NORTH FALLS

Offshore Wind Farm

Applicant's Response to Deadline 5 submissions

Document Reference:	9.87
Volume:	9
Date:	June 2025
Revision:	0

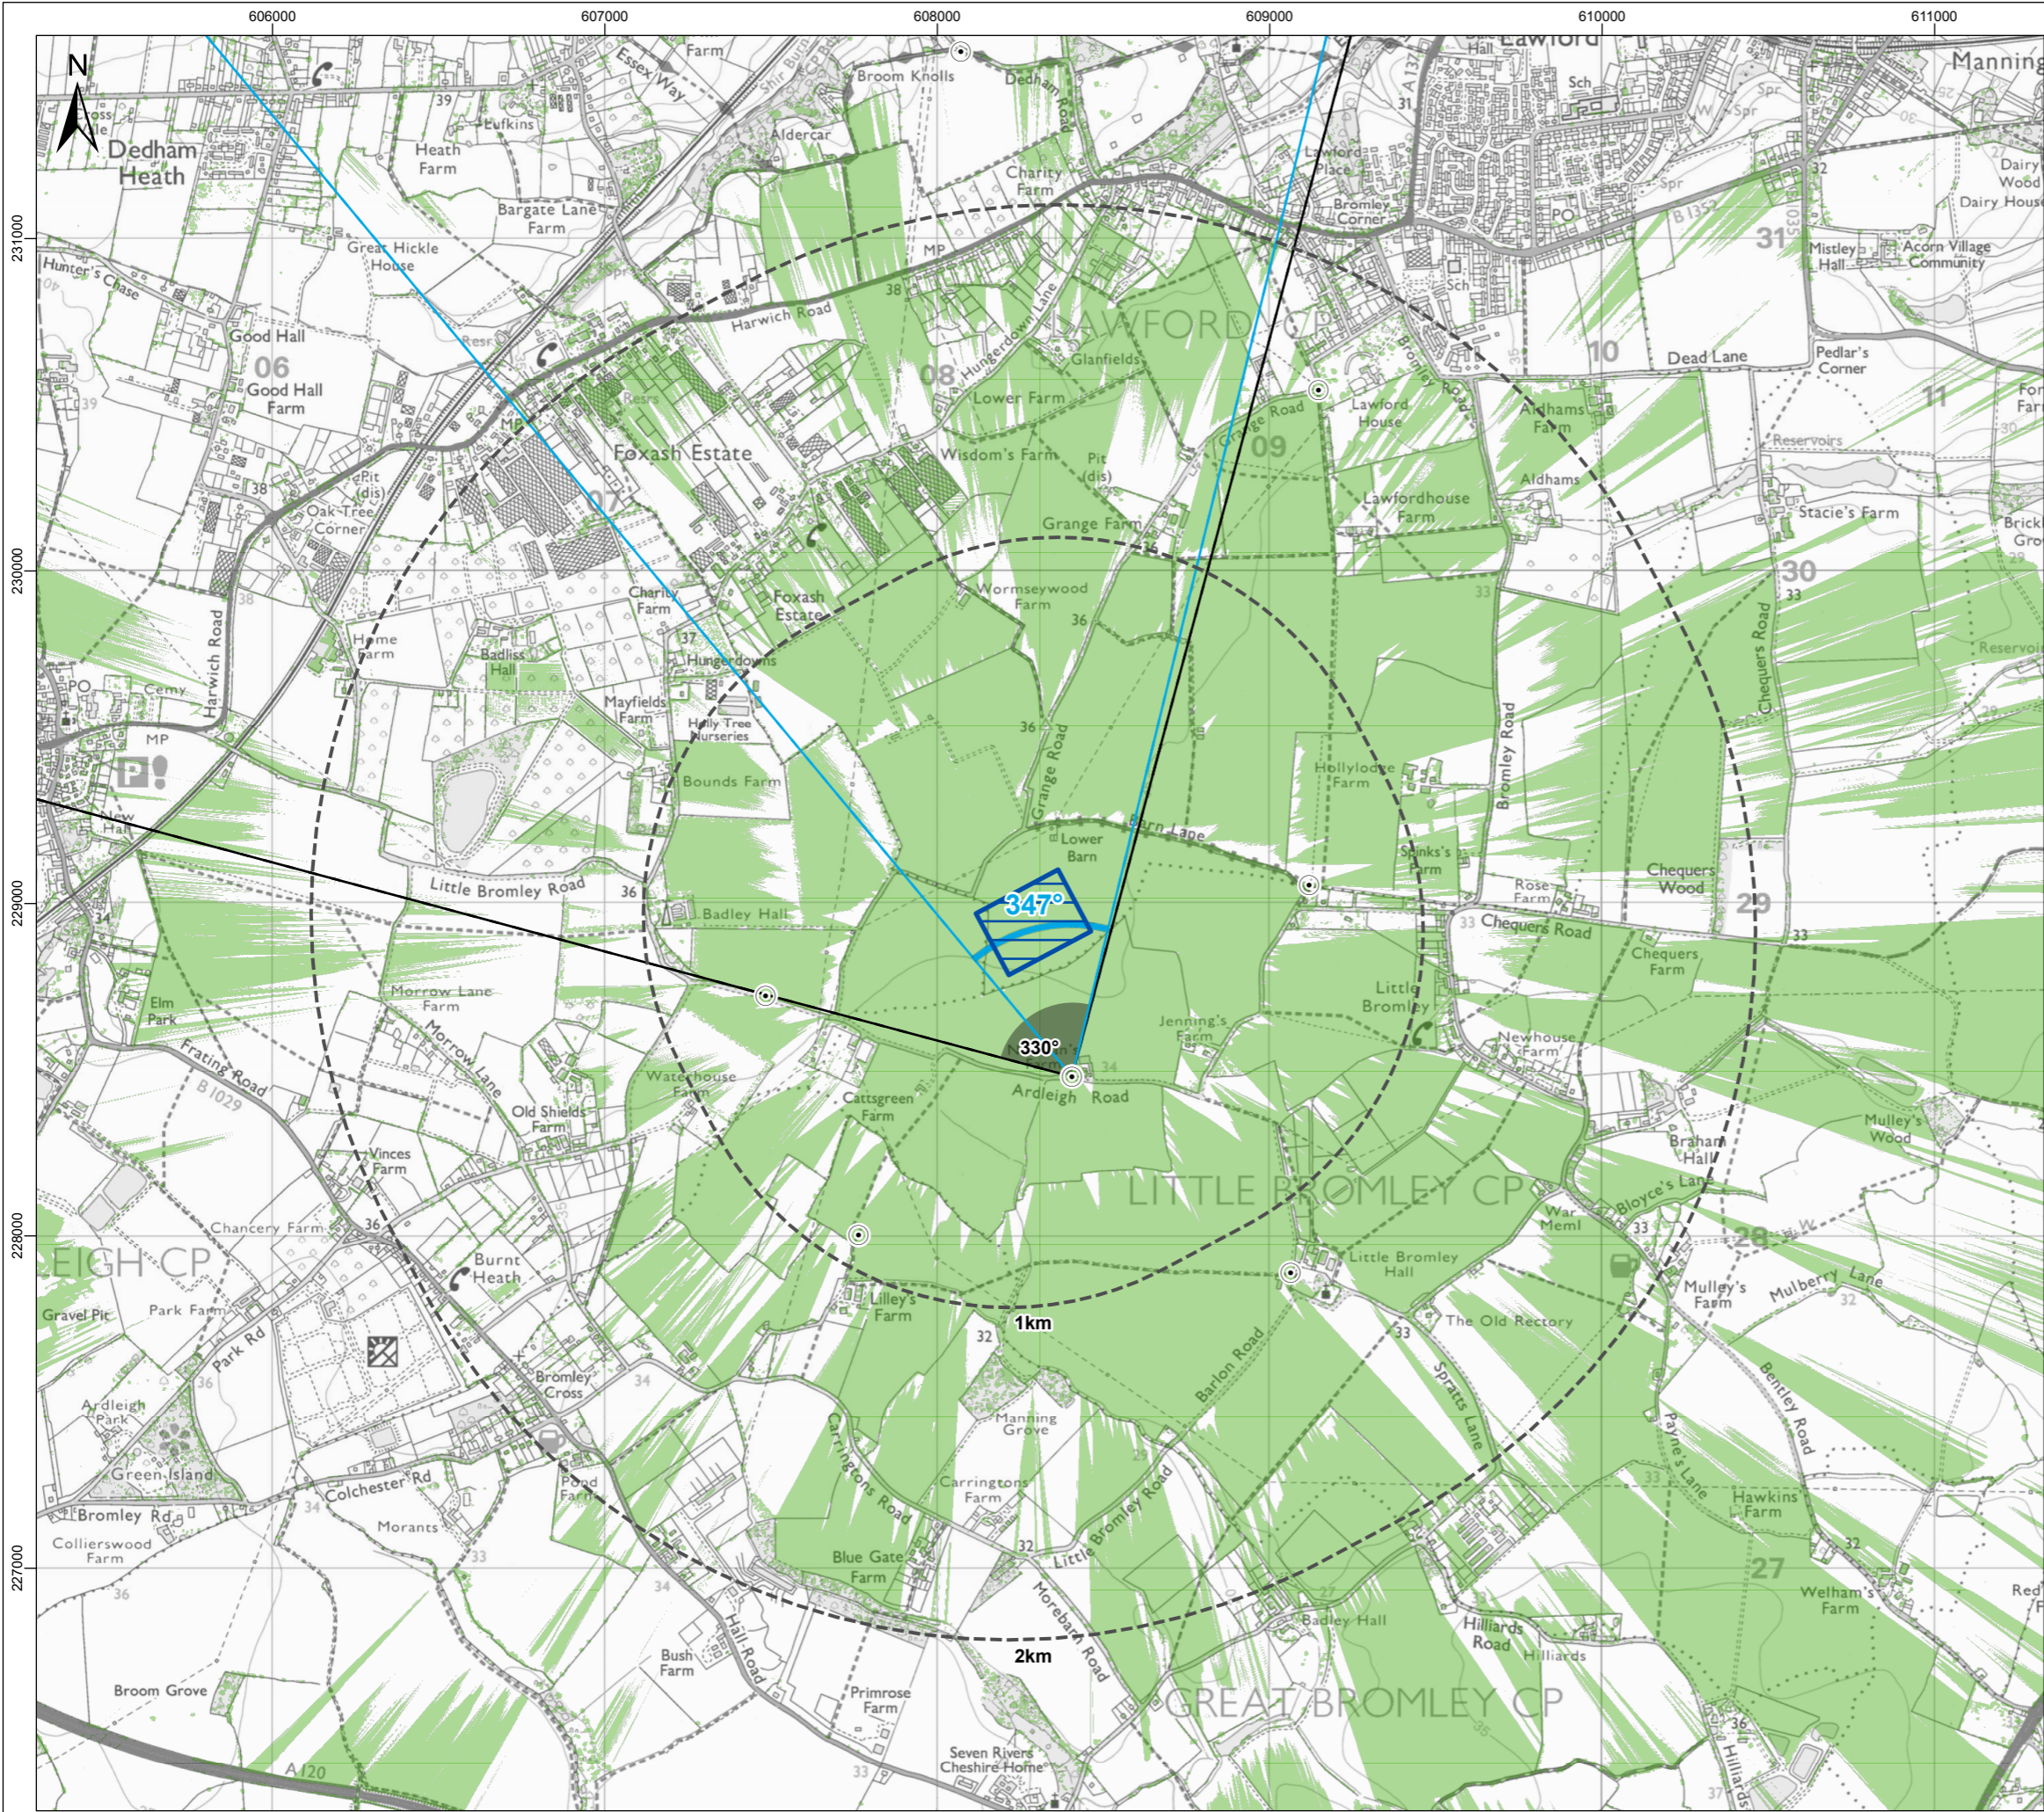
REP5-090_b2	Landscape Visual Impact [REP4-029]	Viewpoint (VP) 2 Bridleway Barn Lane c 600m distance <ul style="list-style-type: none"> • Demonstrates Year 1 would generate a likely Major negative i.e. significant impact. • The N2T pylons are substantially visible adding to the significant negative impacts. 	The Applicant notes the opinions of ECC, and is in agreement that effects on visual receptors at Viewpoints 2, 3 and 5 would be significant, as set out in ES Chapter 30 LVIA [APP-044] . It is agreed that, with proximity to the site, the scale of change is likely to increase. Updated visualisations, which include the Norwich to Tilbury overhead line (OHL) when visible, were provided at Deadline 4 [REP4-029 and REP4-030] .

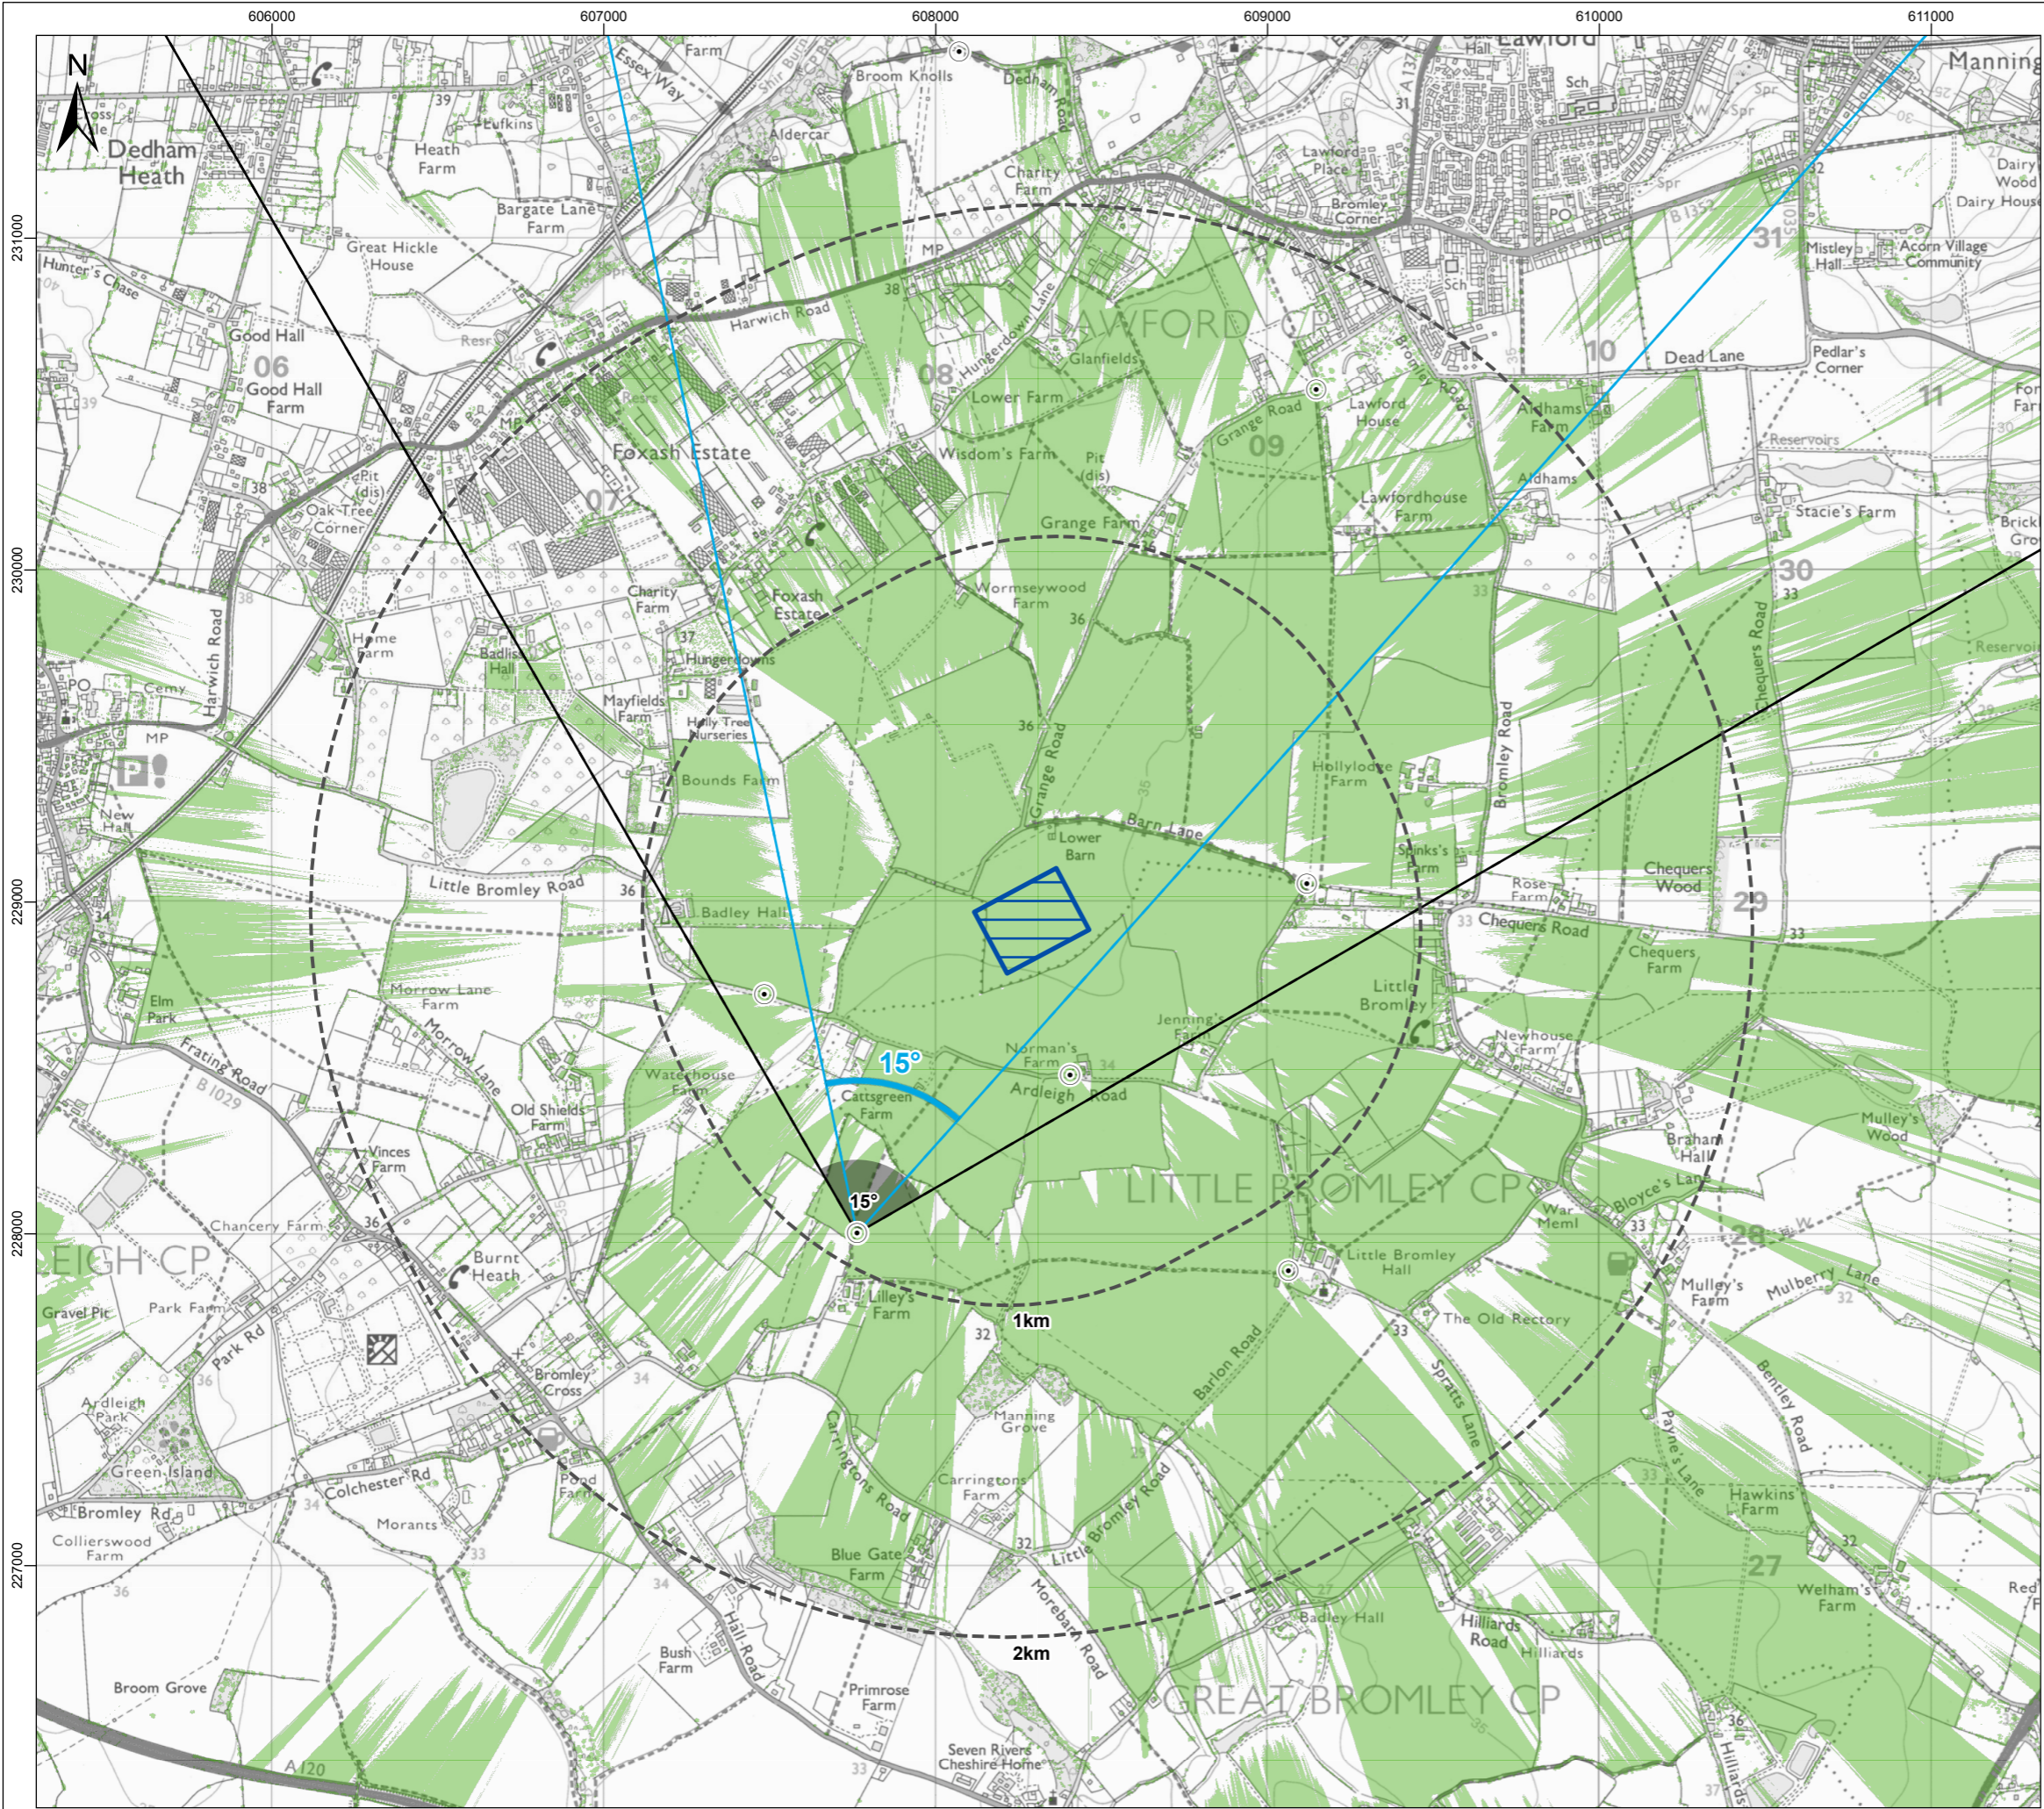
REF	THEME	ECC TDC COMMENT	APPLICANT'S RESPONSE
		<ul style="list-style-type: none"> These impacts will likely magnify for receptors moving closer to the installations along the bridleway. <p>VP 3 Norman's Farm c 350m distance</p> <ul style="list-style-type: none"> Demonstrates Year 1 would generate a likely Major negative i.e. significant impact The N2T pylons are substantially visible adding to the significant negative impacts. These impacts will likely magnify for receptors moving closer to the installations along the Ardleigh Road <p>VP 5 Public Rights of Way (PRoW) Lilley's Farm c 900m distance</p> <ul style="list-style-type: none"> Demonstrates Year 1 would generate a likely Mod/Major negative i.e. significant impact The N2T pylons are not visible but likely to become more visible as you move closer to the installations along the PRoW towards Ardleigh Road. 	
REP5-090_b3	Landscape Visual Impact [REP4-030]	<p>VP 6 Grange Road c 1600m distance north</p> <ul style="list-style-type: none"> Demonstrates Year 1 would generate a likely Moderate negative i.e. significant impact The N2T pylons are visible so add to the negative impacts but from this distance not significantly so. However, for receptors closer to the installations along Grange Road these impacts will likely magnify. A viewpoint previously requested from Grange Road west of the installations rather than due north. <p>VP 7 Public Right of Way near Little Bromley Hall c 1,200m southeast</p> <ul style="list-style-type: none"> Demonstrates Year 1 would generate a likely Moderate/Major negative i.e. significant impact The N2T pylons are visible so add to the negative impacts but from this distance not significantly so. 	<p>The Applicant notes the opinions of ECC, and is in agreement that effects on visual receptors at Viewpoint 8 would not be significant. At viewpoints 6 and 7, ES Chapter 30 LVIA [APP-044] has identified that effects would not be significant. ECC have not presented detailed evidence for why they consider that effects at viewpoints 6 and 7 are 'likely' to be significant.</p> <p>In response to the Examining Authority's Second Written Questions [PD-013], the Applicant has prepared a visualisation from Grange Road to the north, and this has been submitted at Deadline 6 [9.93].</p> <p>The Applicant has provided further detail on the likely visibility of the proposed onshore substation from within the Dedham Vale National Landscape in response to questions raised at ISH2. Please refer to pages 10-12 of Applicant's Response to Actions List for ISH1 and ISH2 [REP4-036].</p>

Indicative Sections

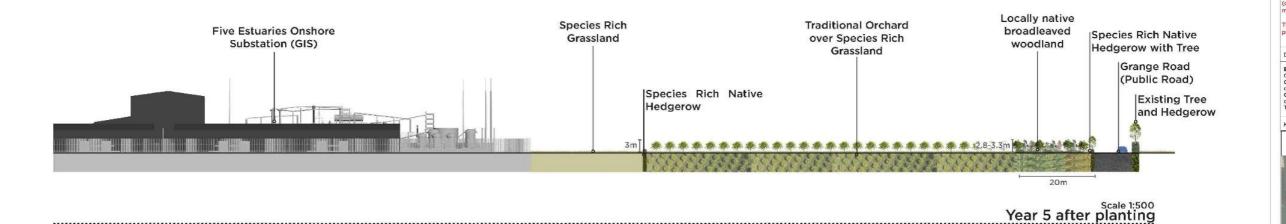
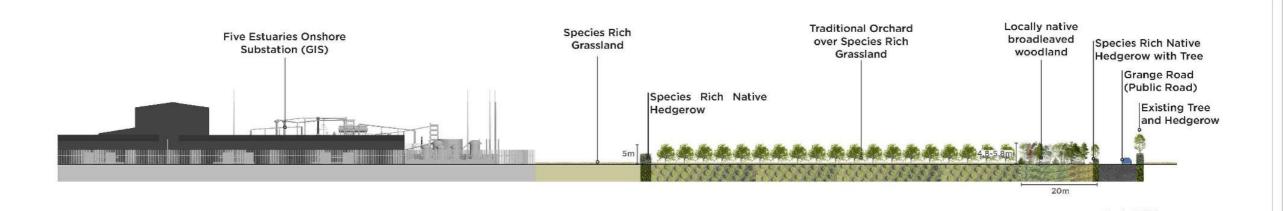
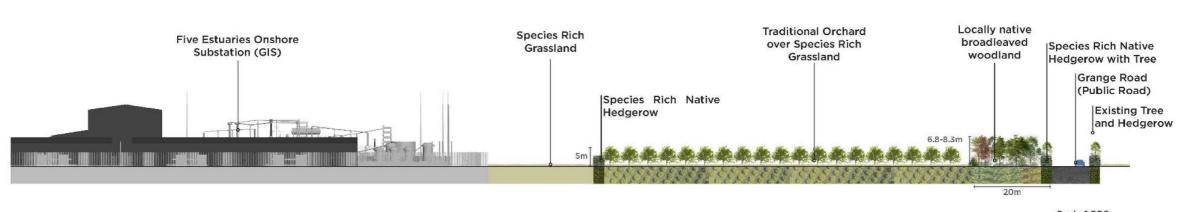
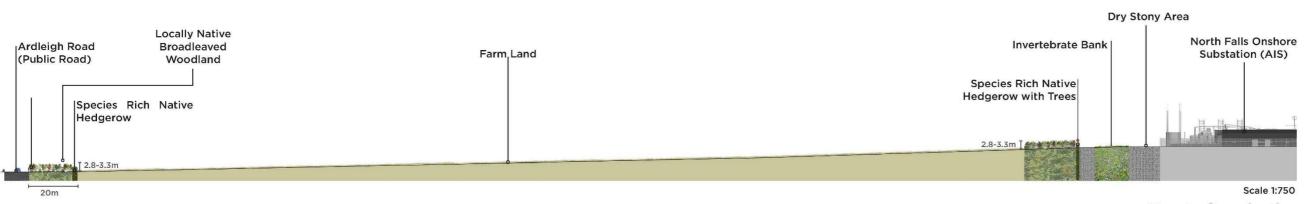
REF	THEME	ECC TDC COMMENT	APPLICANT'S RESPONSE
REP5-090_c4	Green Infrastructure [REP4-023] Indicative Planting	The provision of the indicative planting cross-sections at the onshore substation is welcomed. At detailed design stage, the locations and species of woodland trees, hedgerow, shrub and species rich grassland would require further investigation to ensure that the landscape/GI features demonstrate connectivity to the wider GI network and are designed to deliver multiple functions and benefits, such as contributing to biodiversity net gain (BNG), nature recovery, and flood and water management.	Requirement 7 of the Draft DCO [REP5-008] secures the development and implementation of a detailed landscape scheme, to be based on the OLEMS [REP5-024] , and subject to the approval of the Local Planning Authority.
REP5-090_d1	Built Heritage Clarification of ES Chapter 25	<p>The Applicant has submitted 9.49 Addendum to Environmental Statement Chapter 25 Onshore Archaeology and Cultural Heritage [REP4-035], further to the responses to LIR [REP1-065] and discussions held on 20 March 2025.</p> <p>This sets out:</p> <ul style="list-style-type: none"> the rationale for the level of detail of the setting assessment in 3.3.50 Environmental Statement Appendix 25.3 Onshore Infrastructure Settings Assessment Part 1 of 2 [APP-148] and 3.3.51 Environmental Statement Appendix 25.3 Onshore Infrastructure Settings Assessment Part 2 of 2 [APP-149] The rationale for not assessing the effects of construction activities on the setting and significance of Jennings's Farmhouse in ES Chapter 25 Onshore Archaeology and Cultural Heritage [APP-039] Further rationale for the conclusions of the 3.1.27 ES Chapter 25 Onshore Archaeology and Cultural Heritage [APP-039] <p>The information provided on the setting and significance of Jennings's Farmhouse can be agreed.</p> <p>However, there remains concern regarding the likely significant effects during construction which are listed in Table 2.1. The rationale provided focusses on visual impacts and fails to consider non-visual harm to their setting, in particular from noise, vibration and other nuisances, that would arise from the construction works as required by Historic England's Guidance 'The Setting of Heritage Assets' (GPA3, 2017) and</p>	<p>The Applicant welcomes the agreement on the assessment of effects upon Jennings's Farmhouse.</p> <p>The Applicant can confirm that the assessment presented in both ES Chapter 25 Onshore Archaeology and Cultural Heritage [APP-039] and the Addendum to ES Chapter 25 [REP4-035] did consider non-visual effects from the construction activities (see section 25.6.1.4.1 in ES Chapter 25 [APP-039]). The effects from noise, vibration and other nuisances will not be significant given the distance of the listed buildings set out in REP5-090_d2 below are more than 100m from the onshore project area and the embedded and additional mitigation proposed in the OCoCP [REP5-022] will reduce any significant effects from noise, vibration and dust to minor adverse or lower, which is not significant in EIA terms. The mitigation measures detailed in the OCoCP at Section 1.3.9 – Artificial Light Emissions, Section 1.9 – Air Quality Management and Section 1.11 – Noise and Vibration [REP5-022] are secured via DCO Requirement 8 – Code of Construction Practice [REP5-008].</p>
